**KIRKLEES METROPOLITAN COUNCIL
INVESTMENT & REGENERATION SERVICE**

DELEGATED DECISION TO DETERMINE PLANNING APPLICATIONS

Reference No:	2024/62/93209/W
Site Address:	65A, Westgate, Almondbury, Huddersfield, HD5 8XF
Description:	Alterations to existing ground floor garage and first floor to extend living accommodation (Listed Building within a Conservation Area)
Recommending Officer:	Molly Storer

DECISION – Full Conditional Permission

PROPOSED GROUND FLOOR

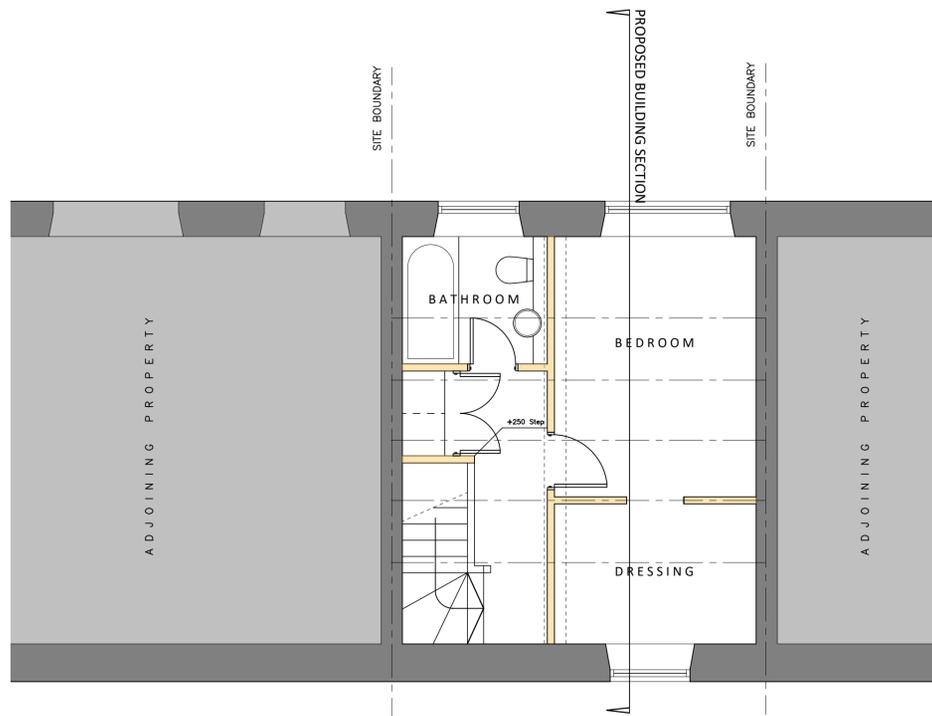
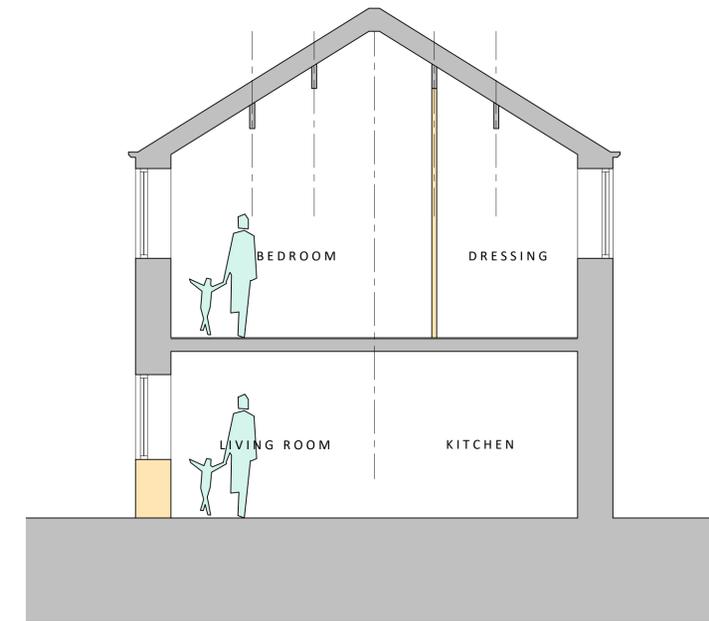
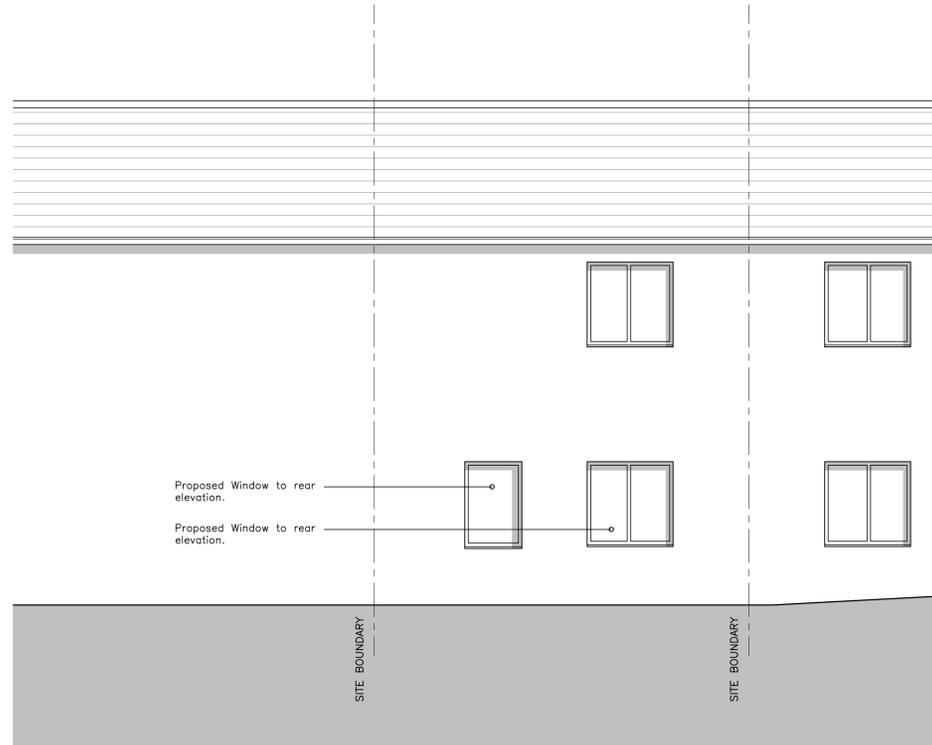
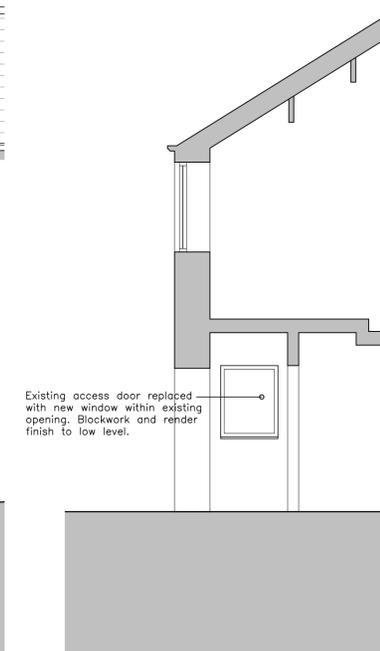
The agent was contacted after comments were received from highways officers with concerns that two off-street parking spaces would be required for a two bedroom house given the loss of the garage space.

To the rear elevation there are two small windows proposed on the ground floor Conservation Officers stated that this was an acceptable design as one of the windows matches and is in line with the existing window on the first floor and the other window is in line with the proposed, creating a harmonious design.

Officer response: it is considered that the additional overlooking as a result of the limited scale windows in the rear elevation will not create any further significant overlooking than those existing in this elevation and on this row of terraces.

The agent responded with amended plans showing the property retained as a one bedroom house having removed the second bedroom hence, the dwelling will remain as one bedroom negating the need for two parking spaces. As the dwelling will only have one bedroom the single parking space provided on the driveway is sufficient. The amended plans also show the original external rear door omitted from the scheme.
